Application for a non-material amendment following a grant of planning permission.

We submit revised plans to be attached to the original planning decision for FUL/2020/0504 in regards to the design for the Sycamore Avenue development. The changes to approved plans include the following details:

FD27 - 1800mm Feather Edge Fence

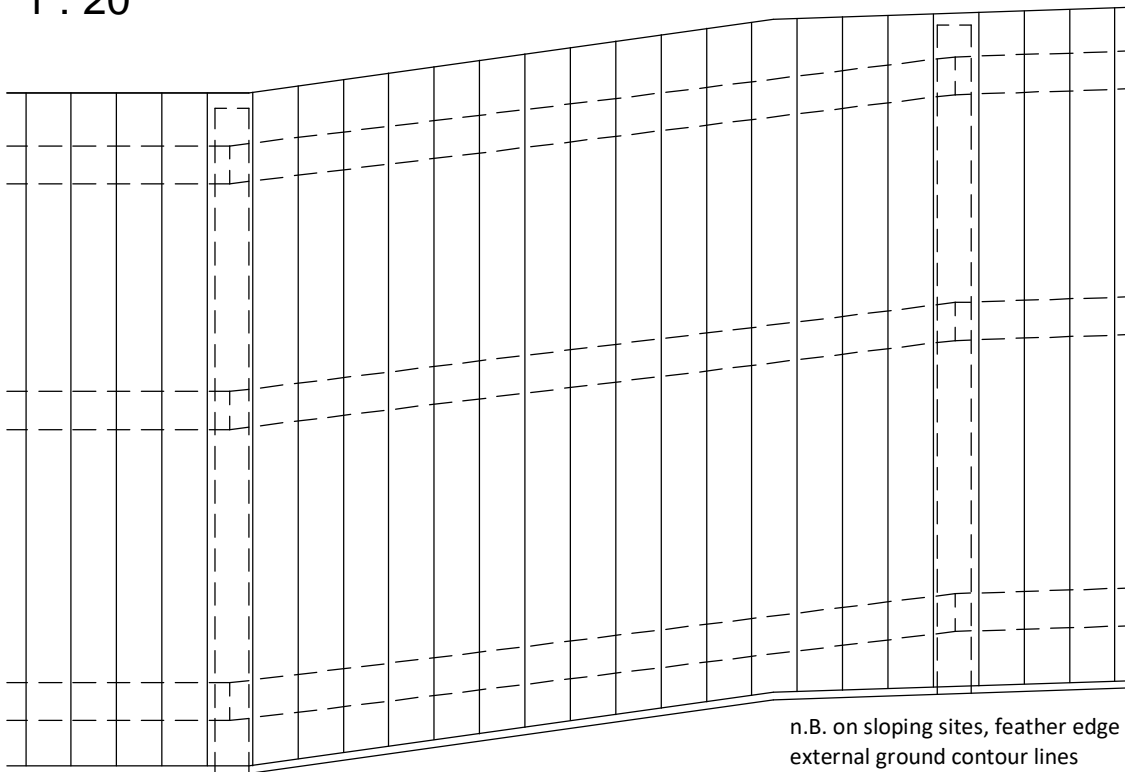
- Change of window colours from grey to white
- Change of fence detail to feather edge fencing
- Omission of patio doors to rear of plots and replacement with single rear door (first floor window lined through to tidy rear elevations)
